Planning Application: 23/02523/F

Location: Kirtlington Village Hall, South Green, Kirtlington

Description: Erection of a single storey community shop and cafe

Comments from Kirtlington Parish Council

drawing title  
 Proposed Drawings

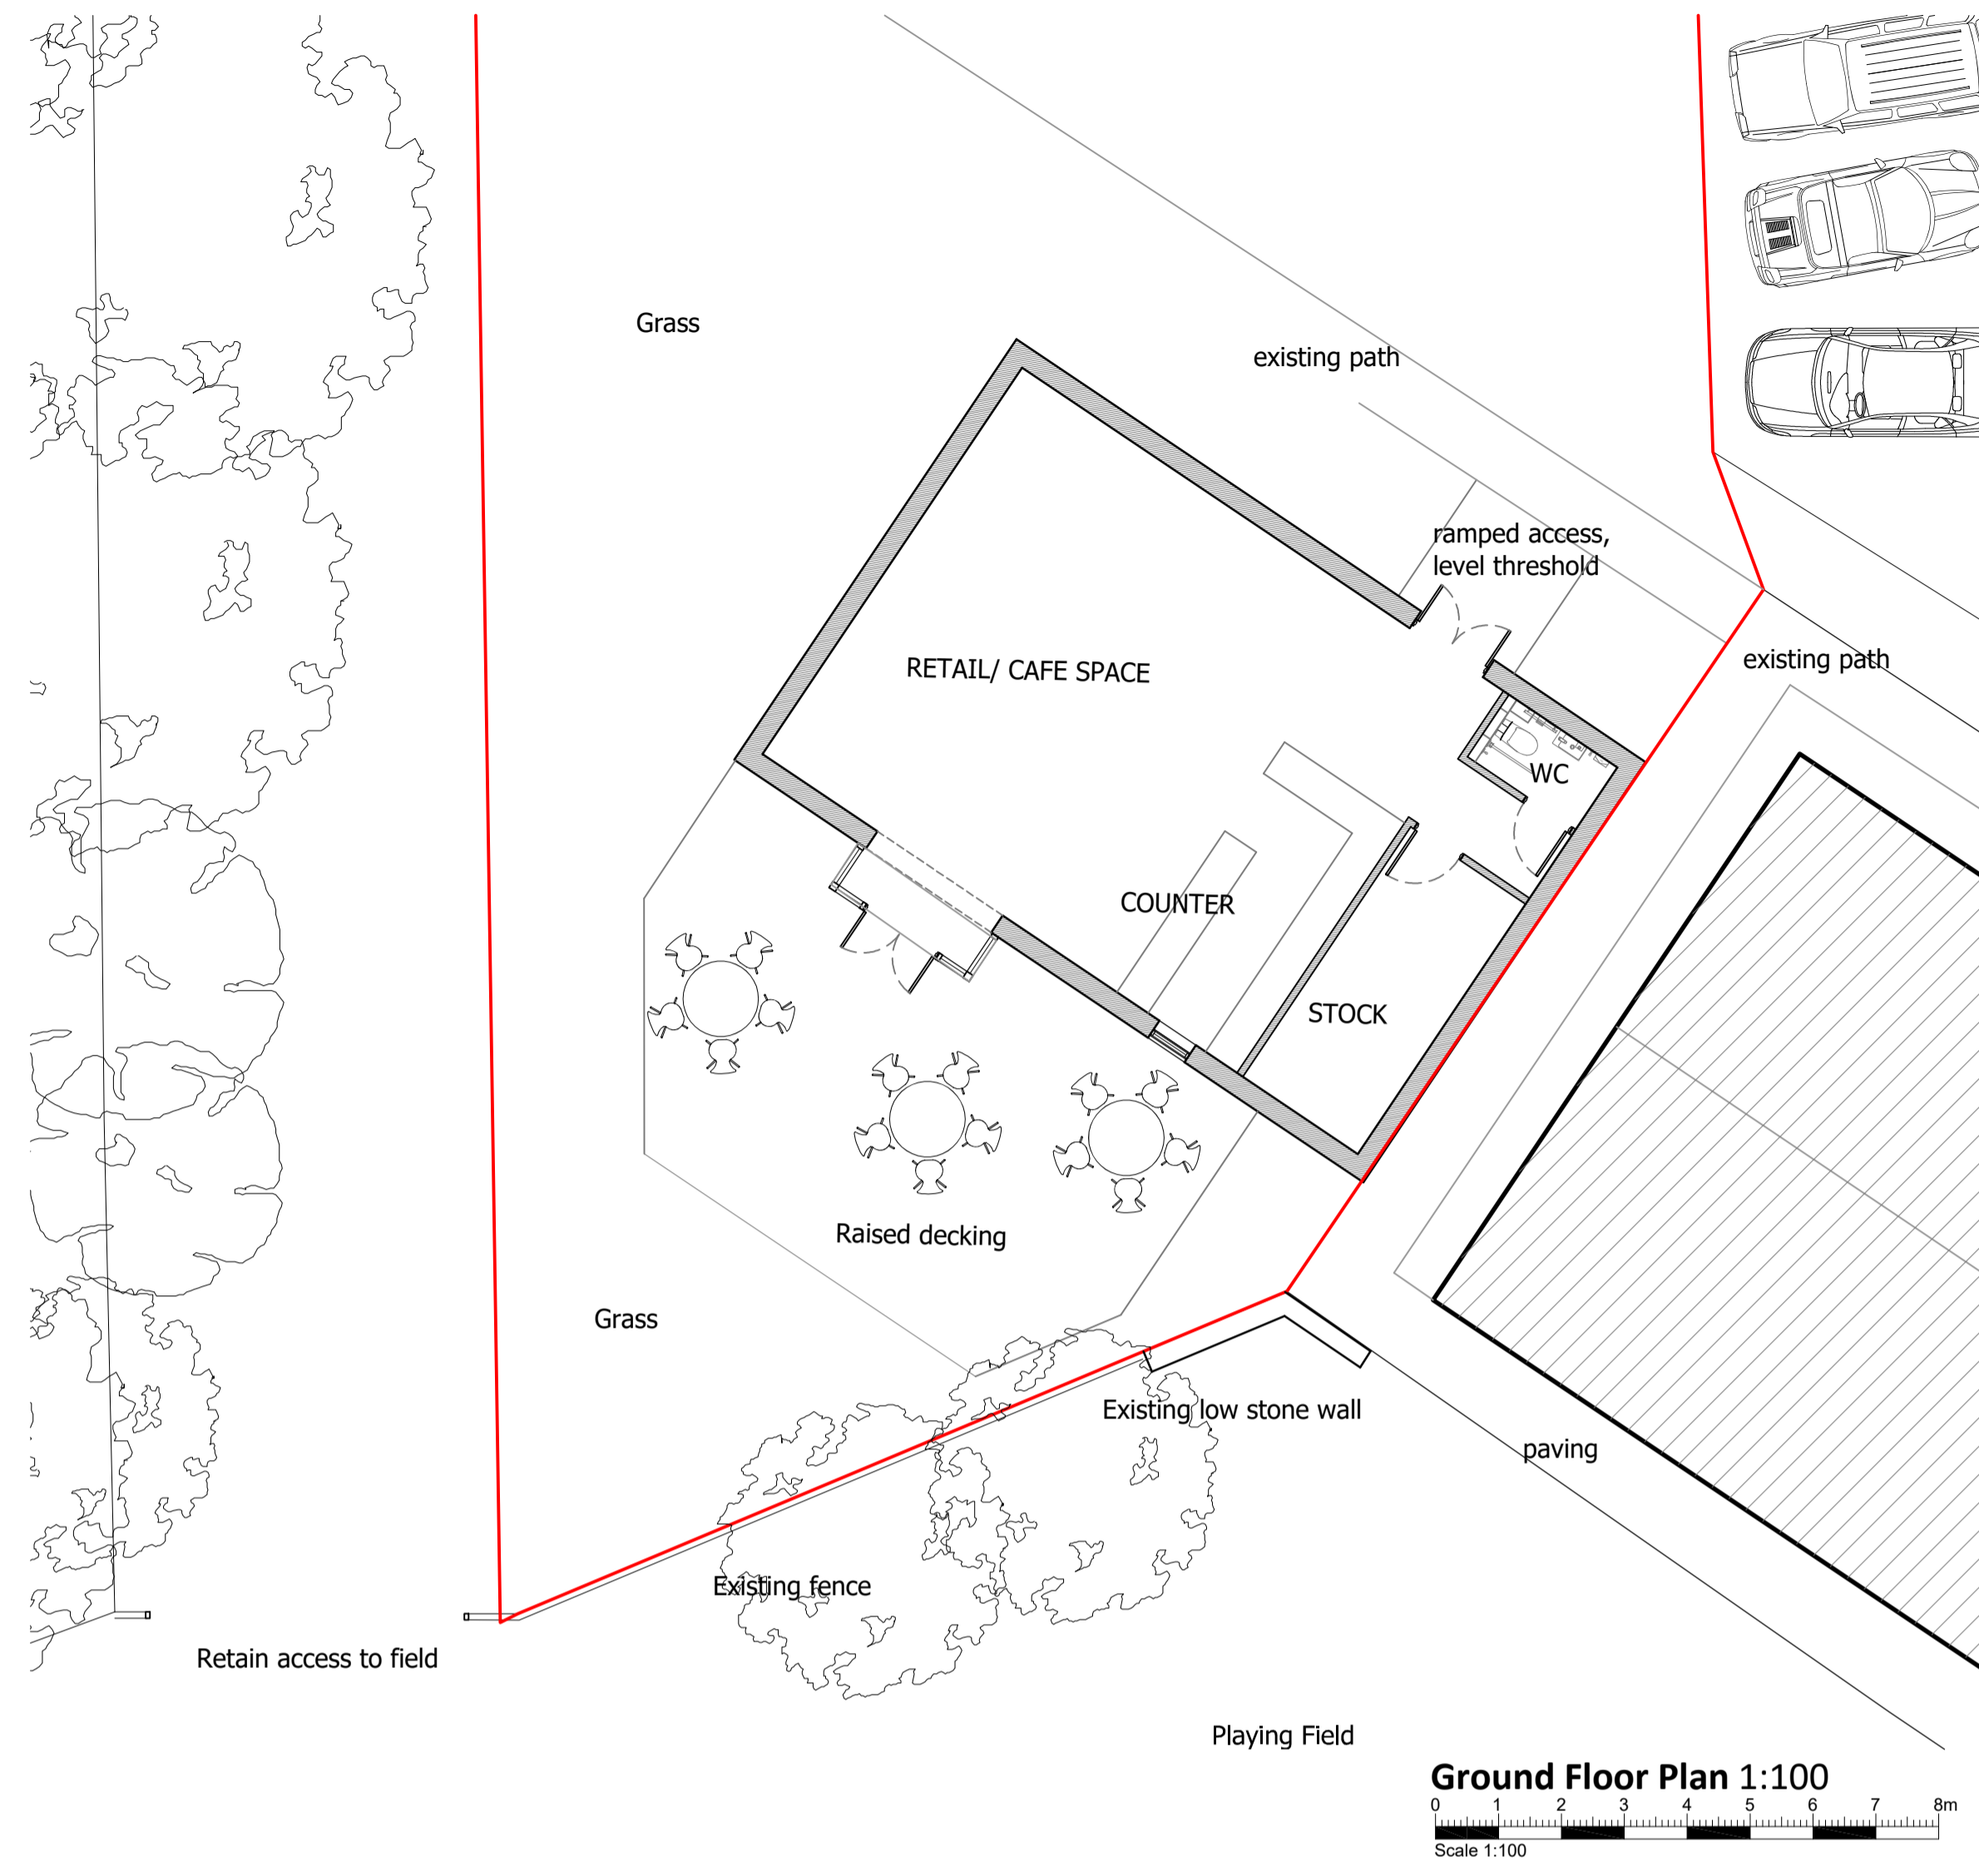
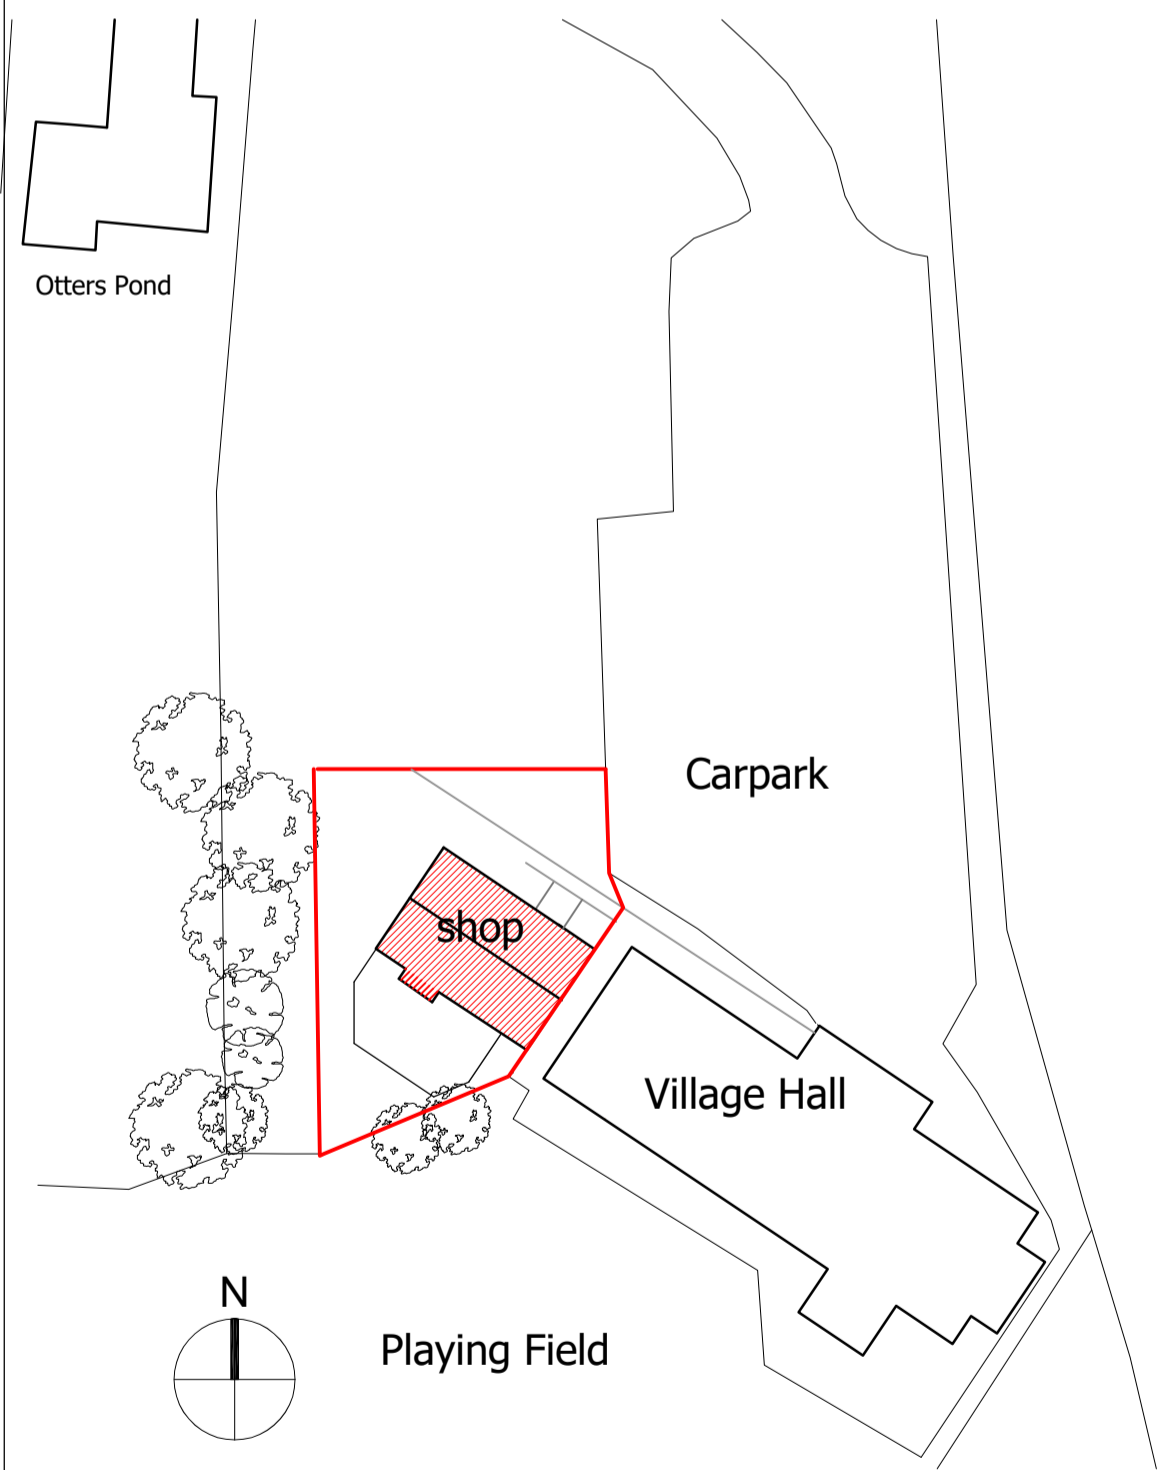
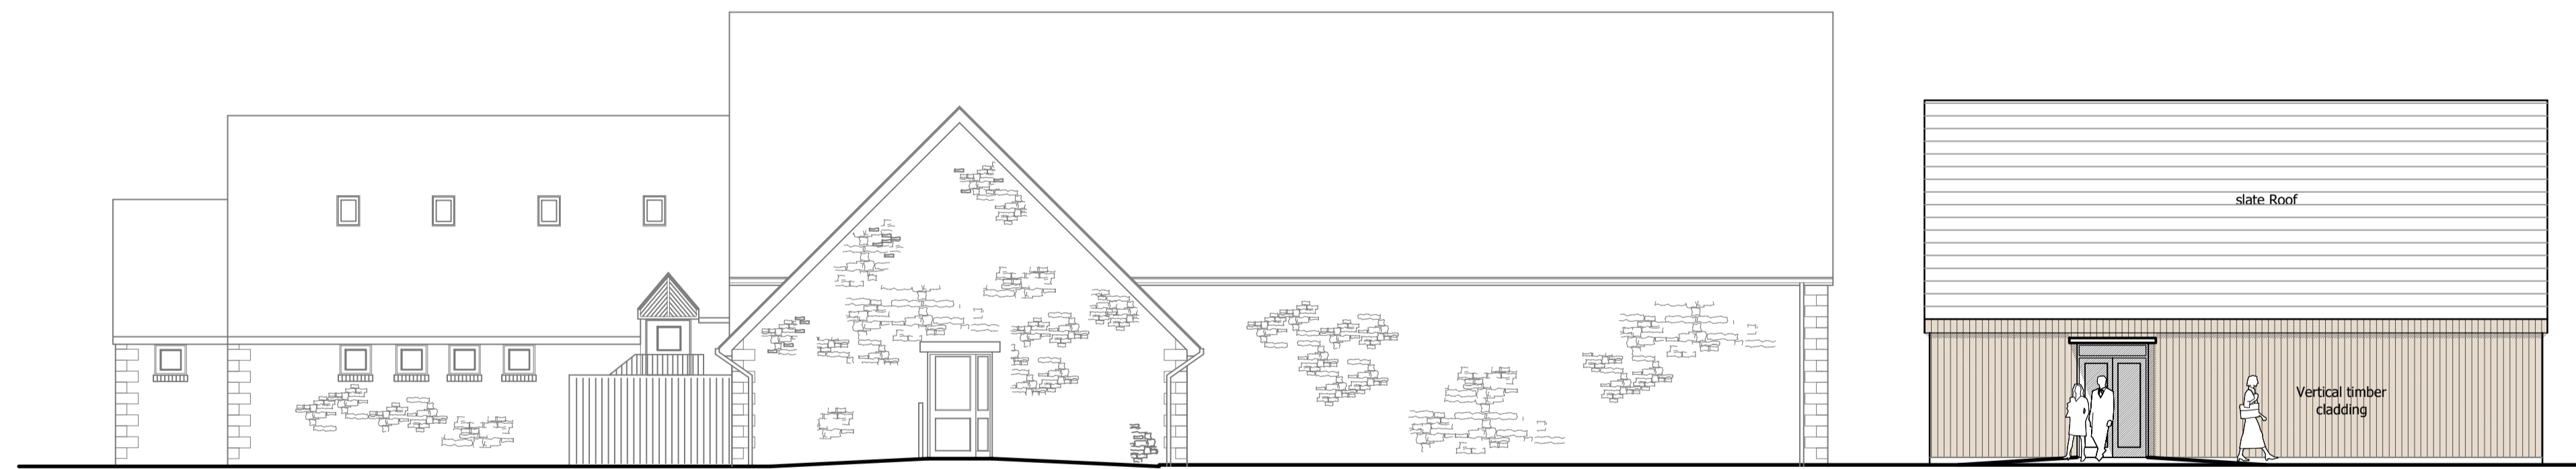
KPC is concerned that the design and building materials do not have synergy with the existing Village Hall and are not integrated with it and that the proposed plan does not respect the form and scale of the village hall. We appreciate however that the applicant has now aimed to address the issues raised in CDC's pre application response, the contents of which have been shared with the Parish Council. We have noted, in particular, the revised conclusions of the Conservation Officer.

It does not comply with the Mid Cherwell Neighbourhood Plan Policies PD4 which aims to protect important views and vistas and PD5 which controls building and site design. However, we note that the proposed plan now locates the building nearer to the Village Hall. Although it is still not integrated with the Hall and a wooden structure seems unlikely to enhance the view, it does appear to be located in a less exposed position than on the former plan.

The pre application suggested considering amending the design and the proposed construction material. This has not noticeably changed on the architect's drawing and therefore would not be in sympathy with the village hall. However, we note the applicant's intention to reference the wooden boarding on the Village Hall for the proposed building. We further note that similar wooden buildings have been approved elsewhere recently within the Registered Park and Garden.
